FROM: Katie Kurek

SUBJECT: BE/180/16/PL - 1 No. dwelling. This application affects the setting of a Listed Building.
More Information

Land adj to 2, North Bersted Street, Bognor Regis, West Sussex, PO22 9AD

Project
NORTH BERSTED STREET
BOGNOR REGIS
Drawing
Site Lines & Parking

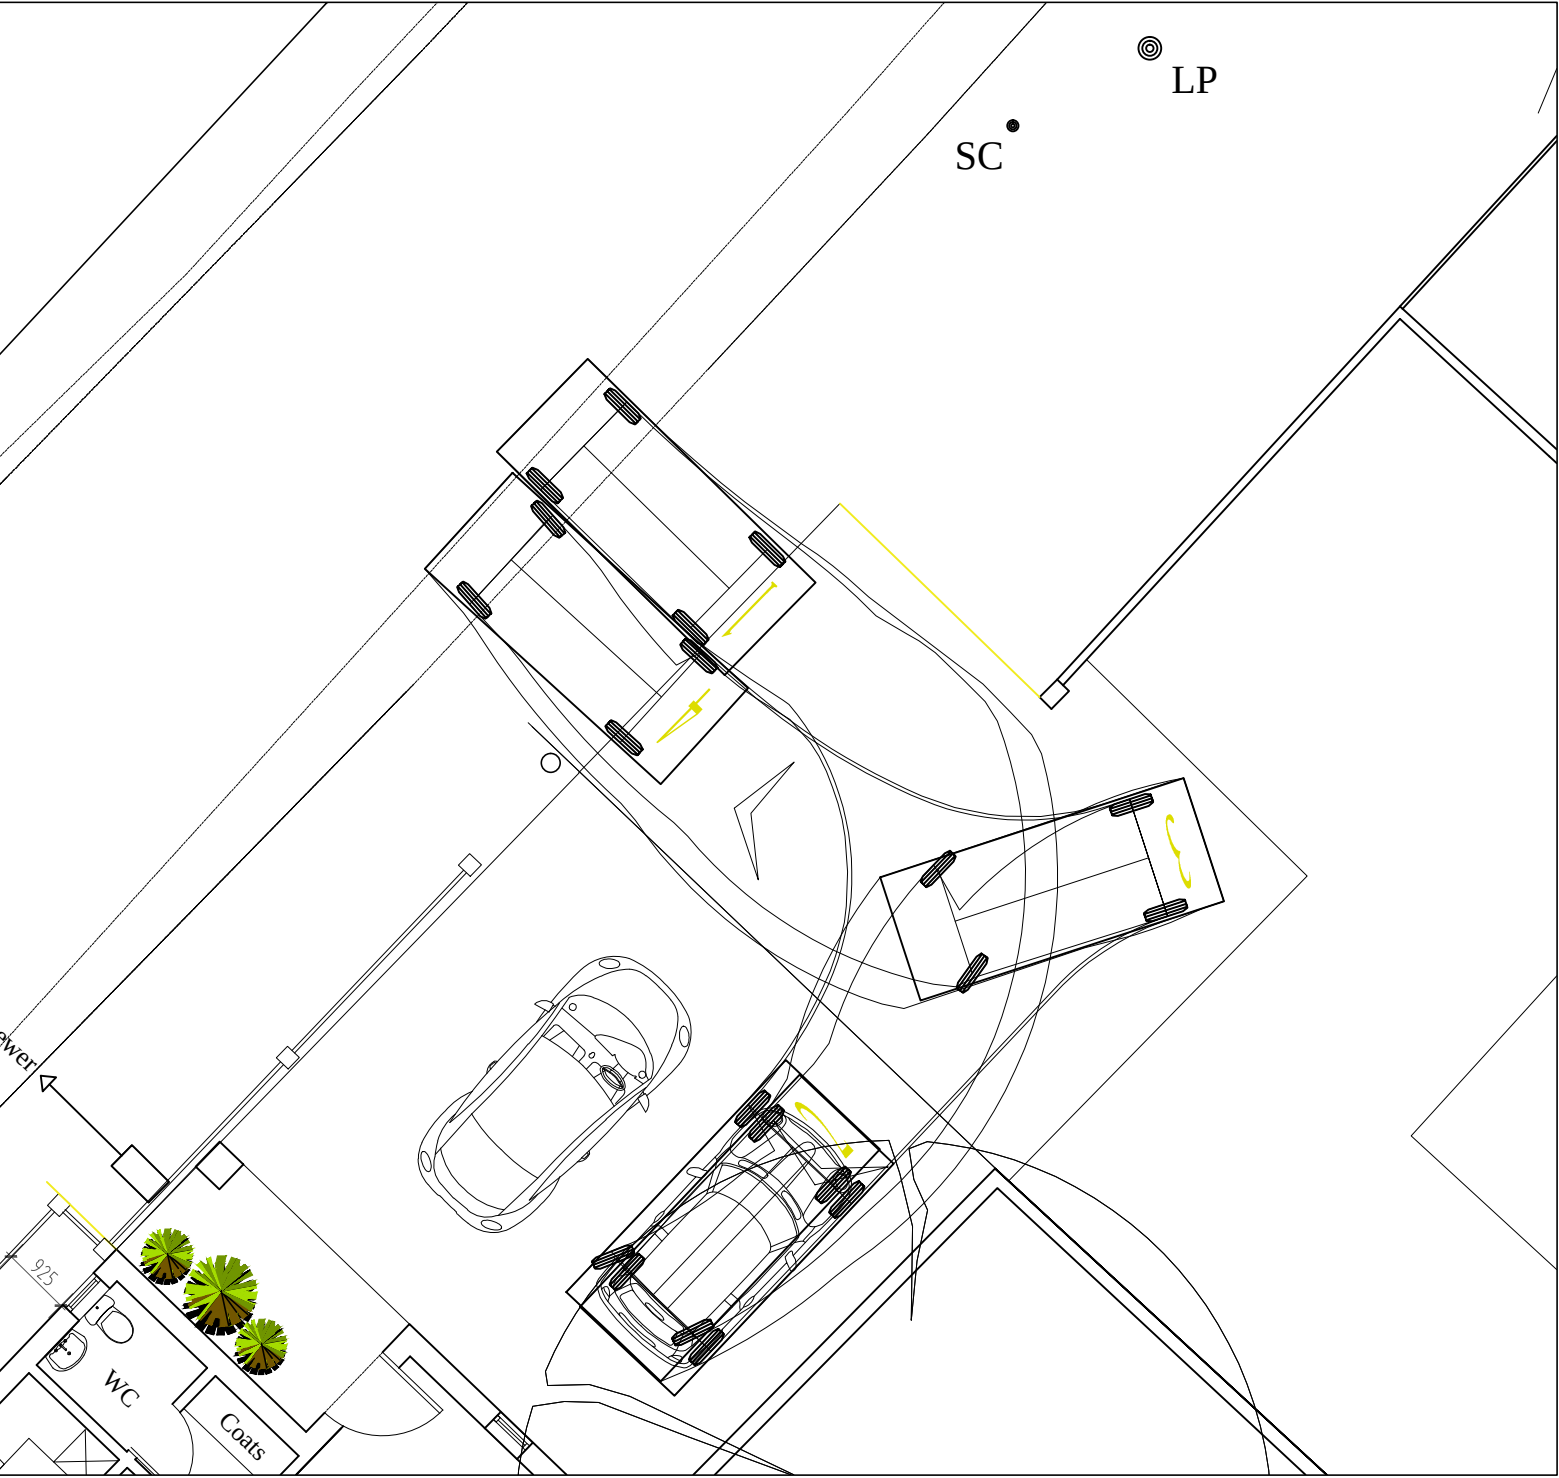
The cars used on the plan are smaller than average recommended (4.5-4.8 m by 2 m). Therefore the swept path analysis is not accurate. Please amend this using car of sufficient dimensions to demonstrate that they can turn in this area.

The existing parking arrangements have not been indicated on the plans. A line is shown along the frontage separating the site from the proposed and from the public highway. Is it proposed for this to be open or a gate installed for vehicular access to the side of no. 2? Please outline on an amended plan where existing parking, and turning if proposed, are to be situated.

It was previously noted that visibility to the south could be improved by reducing height of existing boundary fence. It does appear that the fence has been set back to improve visibility upon exiting the site. However, the splay appears to extend to the far-side carriageway edge and not the nearside. Please amend visibility splays to demonstrate achievable visibility to the south, from 2.4 metres back from the carriageway edge into the centre of the access. The applicant should also clarify what is proposed with the strip of grass verge that will result from setting the fence back. Is it proposed that this is adopted to become public highway or will it remain private and thus maintained by the applicant?
